Application by National Highways for the Lower Thames Crossing
The Examining Authority's written questions and requests for information (ExQ2)
Issued on 10 October 2023

SCALE 1/100
 DATE
 DRG. No. 460/2

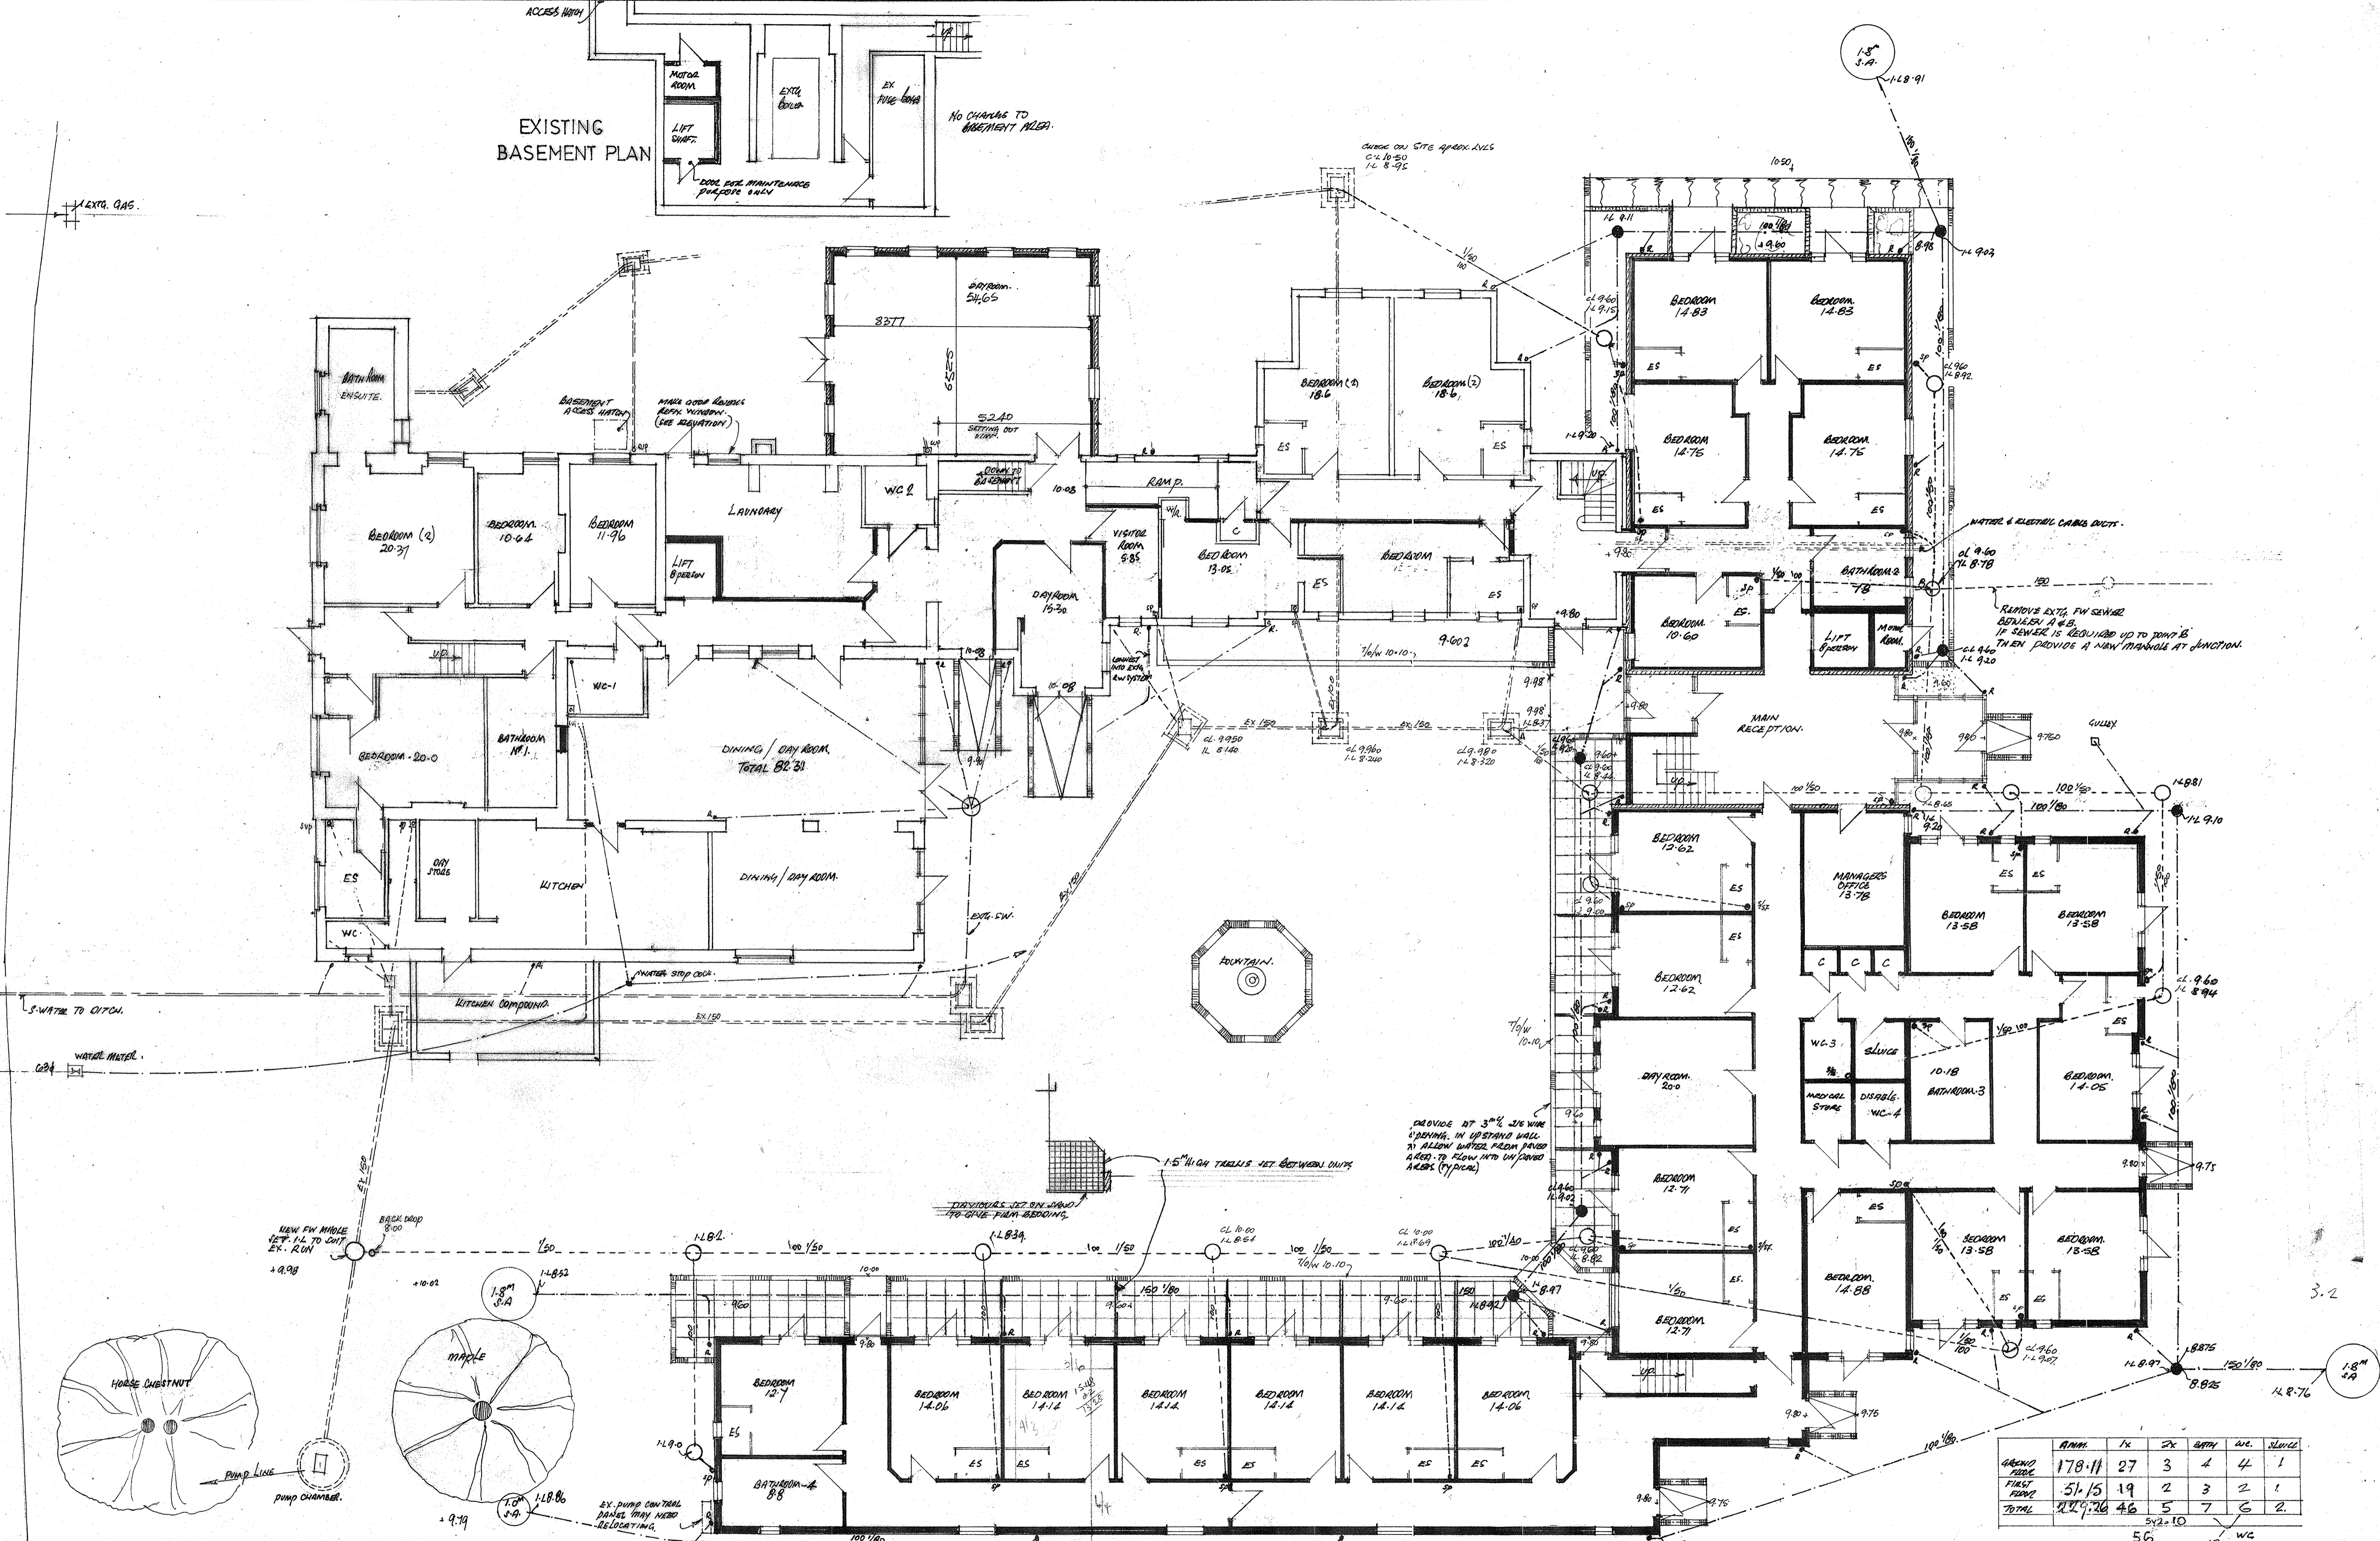
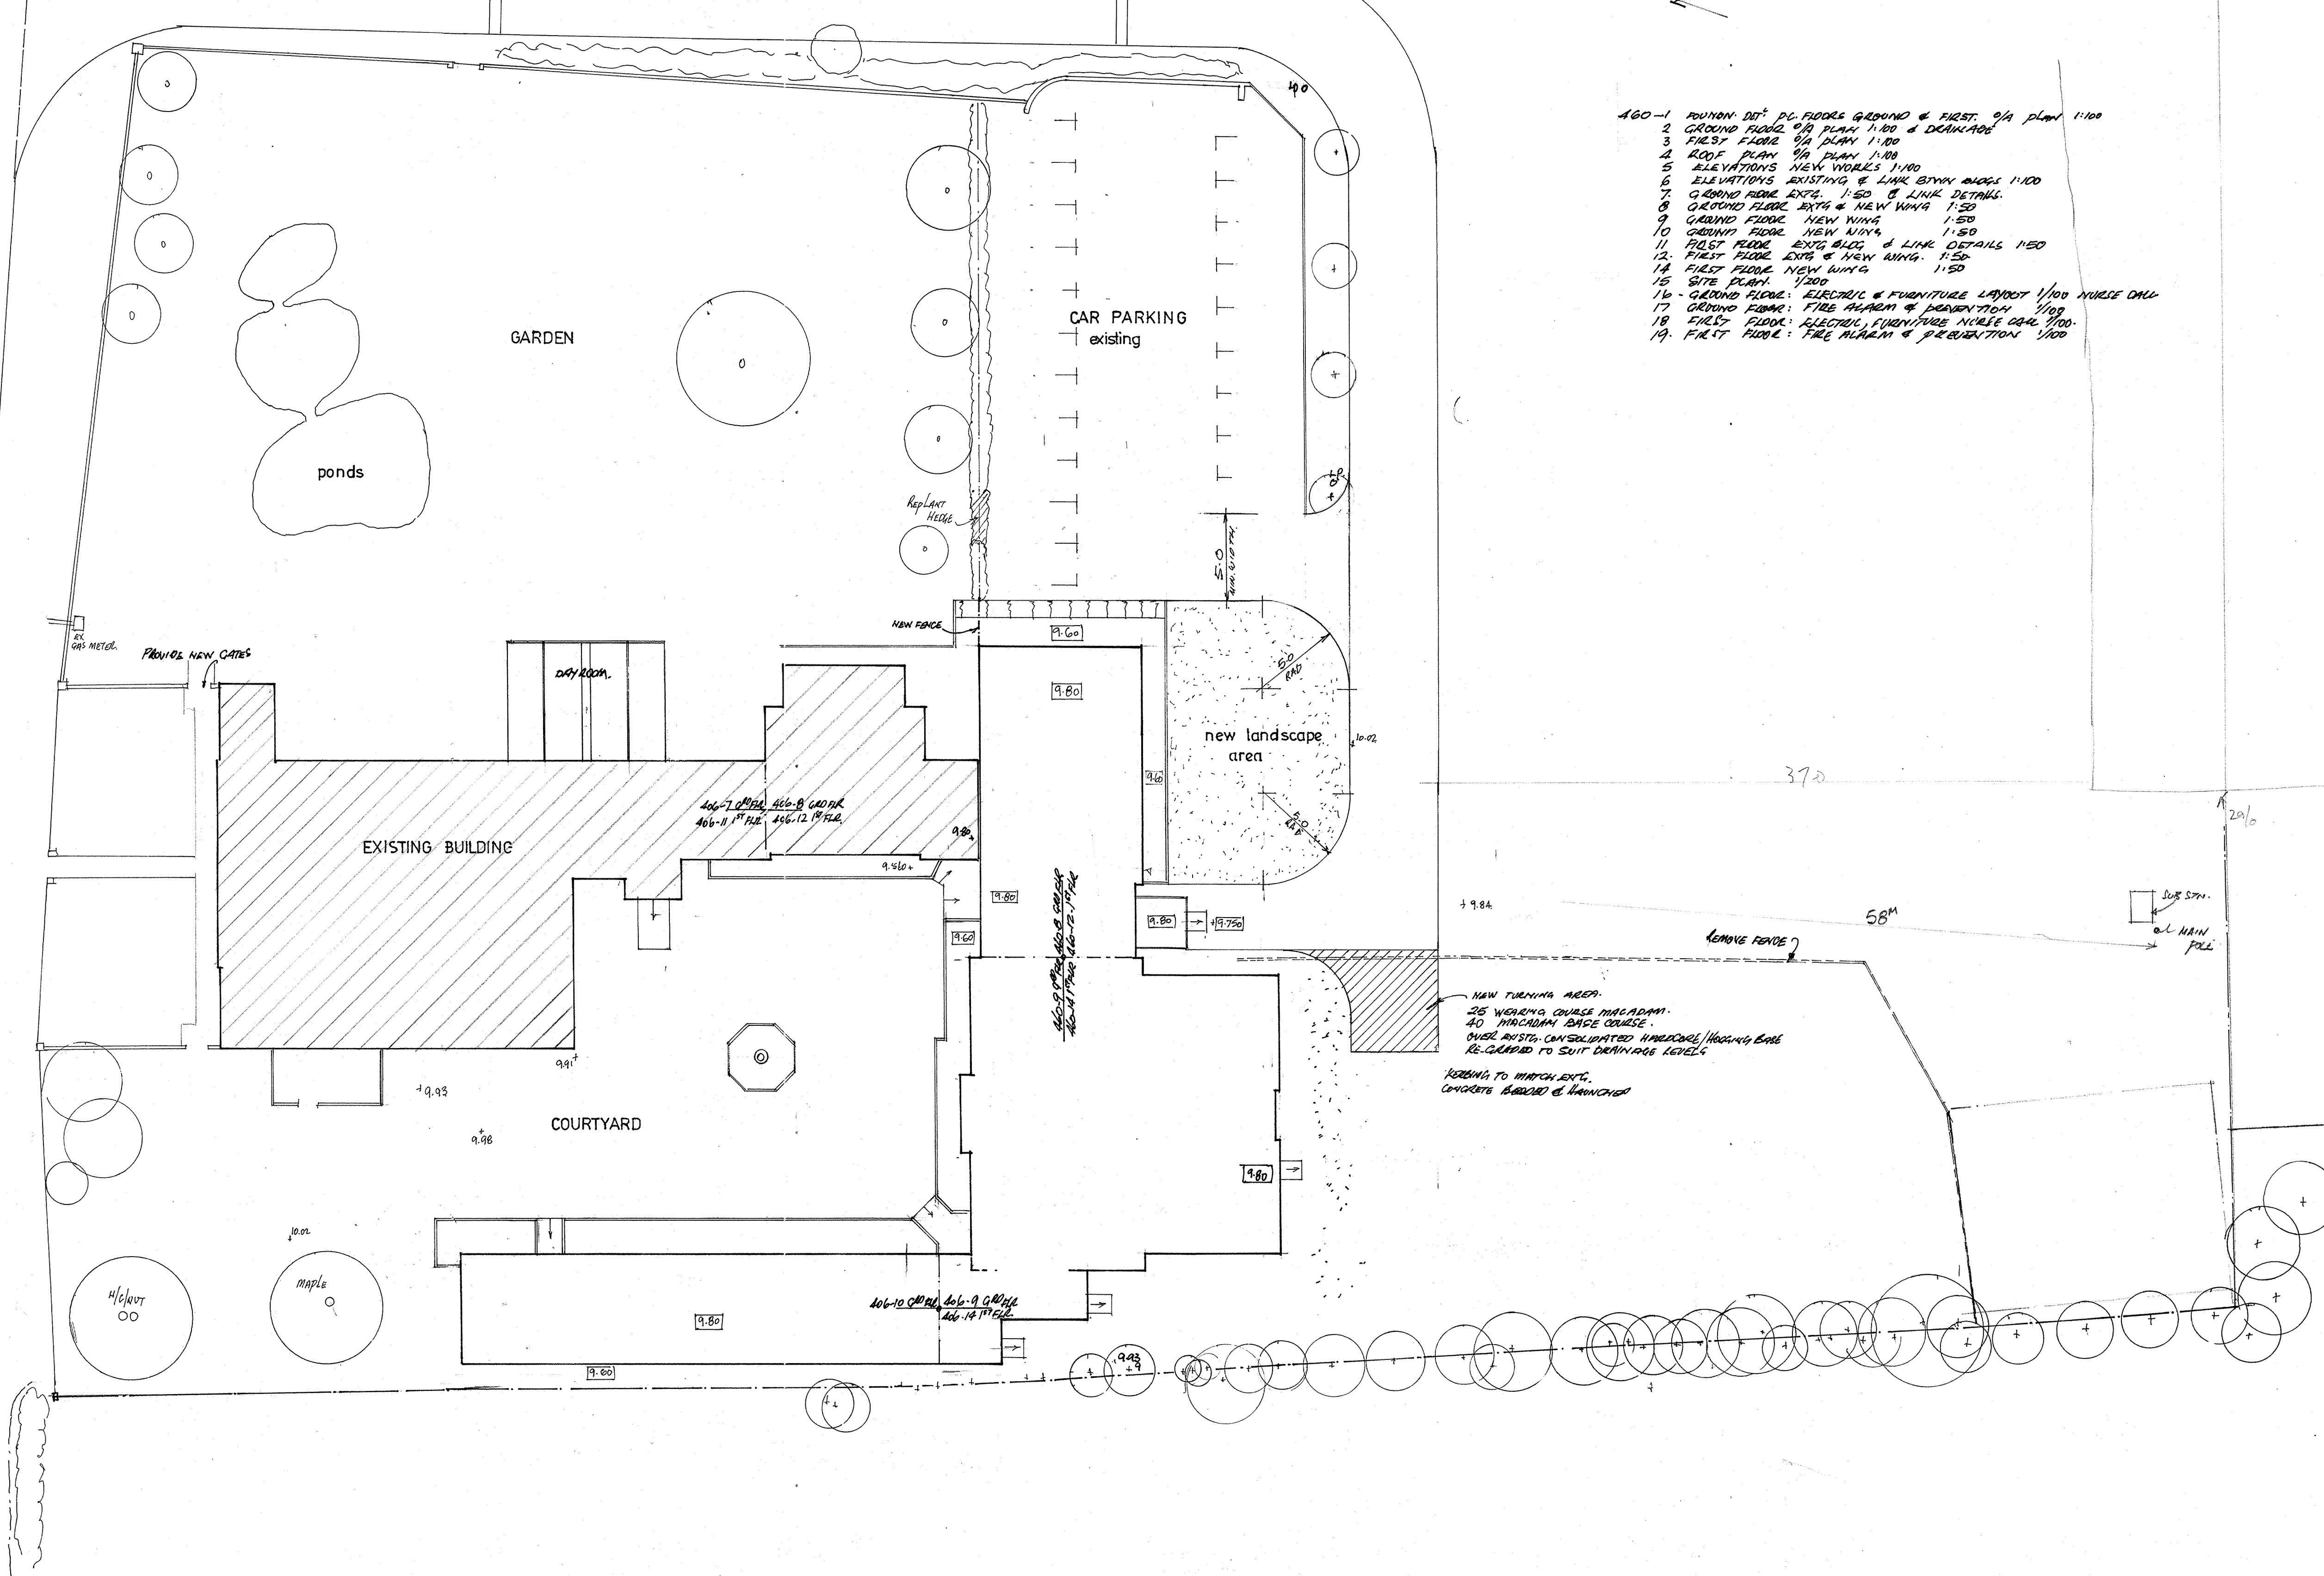
Q9.1.8	Applicant	<p>Whitecroft Care Home: operational noise</p> <p>The submissions from Whitecroft Care Home (including [REP4-382]) indicates that operational noise levels may increase beyond those currently experienced, particularly in respect of the south façade of the building. Please provide commentary on this matter and indicate how monitoring and mitigation could be put in place to avoid this?</p>
Q9.1.9	Applicant and Whitecroft Care Home (Kathryn Homes Ltd, Runwood Homes Ltd and Runwood Properties Ltd)	<p>Whitecroft Care Home: construction vibration</p> <p>Can these parties liaise together to provide details of additional information that could/should be provided to inform vibration mitigation and how this could/would be secured in the Code of Construction Practice (or other control document)?</p>

*Local Landscape Character Area boundaries of the Kent Downs AONB LCA, West Kent Downs, Sub-areas Cobham and Shorne*

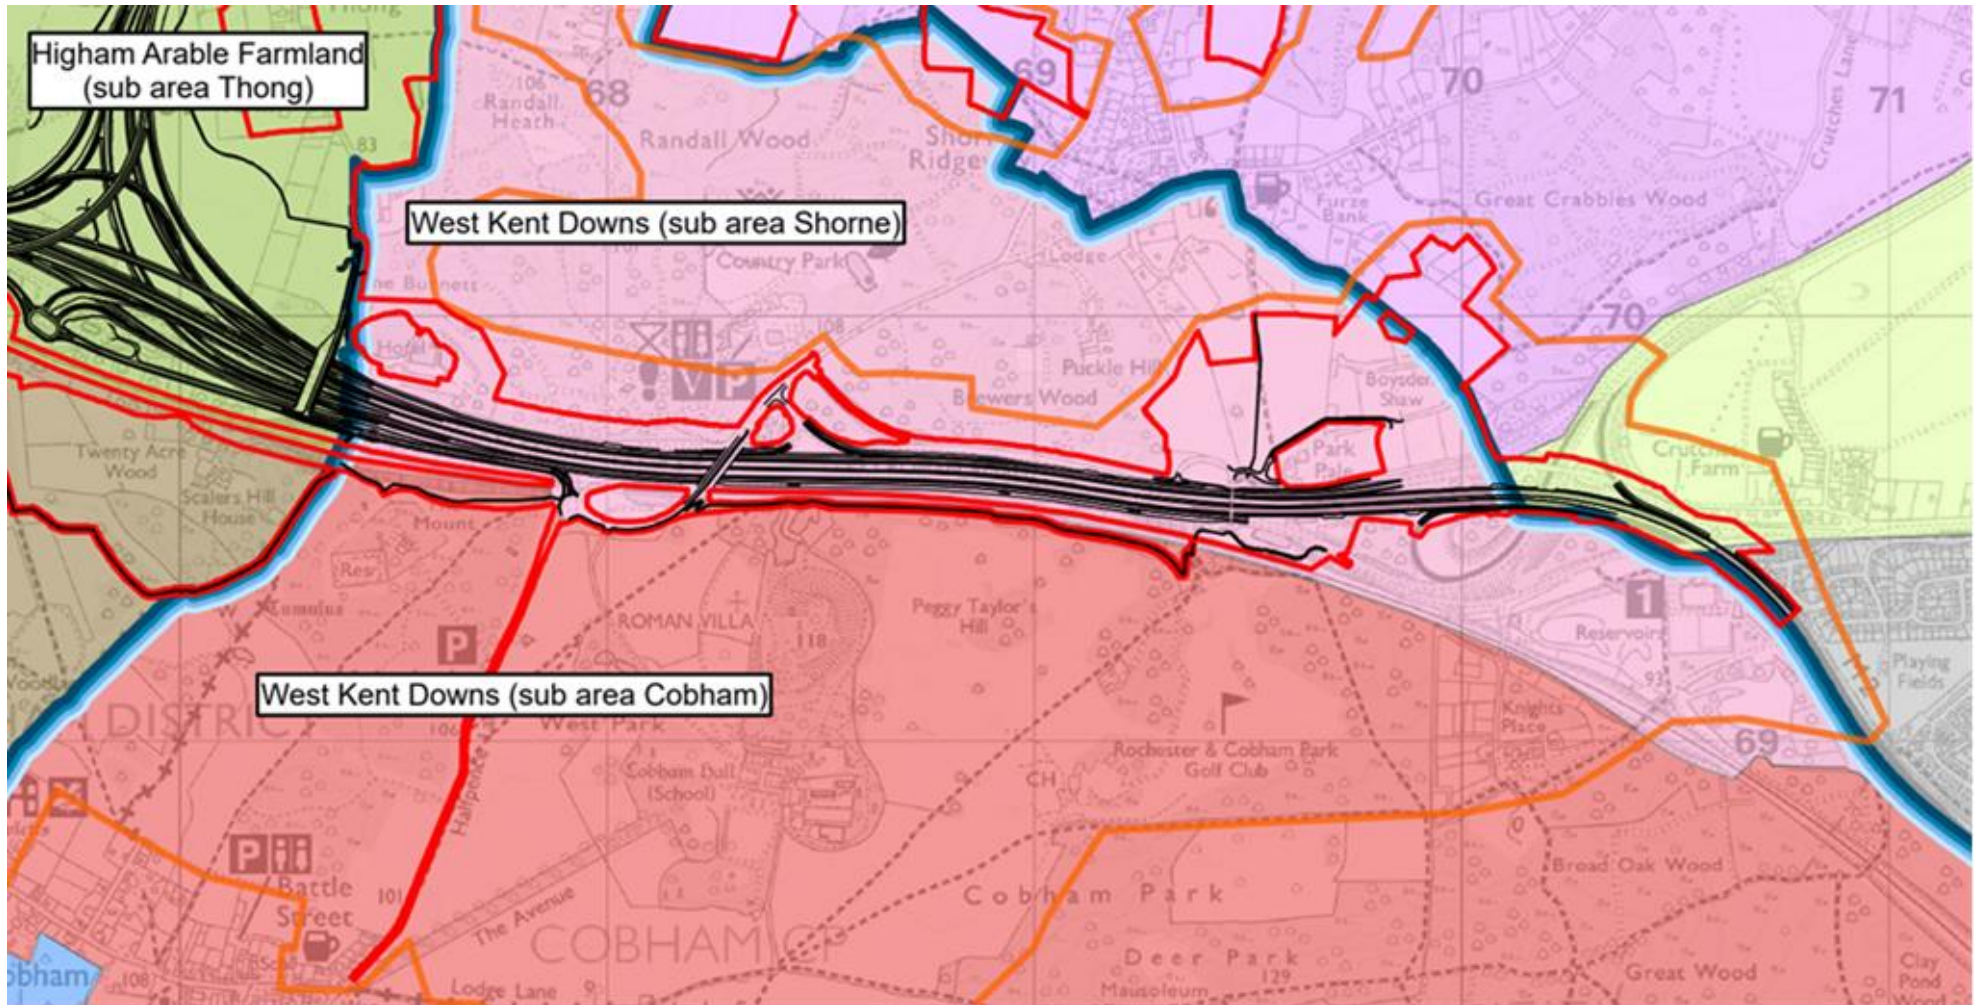
<p>12.2 Landscape impacts including riverscapes and visual severance</p>		
<p>Q12.2.1</p>	<p>Applicant</p>	<p>Landscape character: regrading of sensitivity and effects (sub area Cobham)</p> <p>The Applicant’s response to ExQ1 Q12.2.6 states that “Since the Development Consent Order (DCO) application made in October 2020 was withdrawn, a thorough review of the landscape impact assessment in Environmental Statement (ES) Chapter 7: Landscape and Visual [APP-145] has been undertaken in conjunction with further refinement of the Project design... The assessment of high sensitivity for the West Kent Downs (sub area Cobham) Local Landscape Character Area (LLCA) has regard to the updated assessment of susceptibility to change set out in Table 1.3 of ES Appendix 7.9: Schedule of Landscape Effects [APP-384], which explains that ‘... due to the presence of the existing A2 corridor and HS1 along the northern boundary of this LLCA, the receptor has some ability to accommodate the Project without substantial loss of its overall integrity.’</p> <p>The ExA is unclear in respect of the reasoning behind this explanation for the regrading of sensitivity, noting that the A2 corridor and HS1 were adjacent to the northern boundary of this LLCA when the October 2020 application assigned the Cobham sub-area a ‘very high’ sensitivity.</p> <p>The Applicant’s response does not provide a meaningful justification for the changes in definition of baseline conditions between the two submissions (2020 and 2022) when the landscape baseline has not changed in the intervening period. While visual baseline data may require updating to reflect modifications to the design (ref. GLVIA3), the Applicant does not explain the specific design changes that have resulted in changes to the visual baseline in this location. The ExA requires the reasons for the review and update of baseline conditions by the Applicant to be made clear.</p>
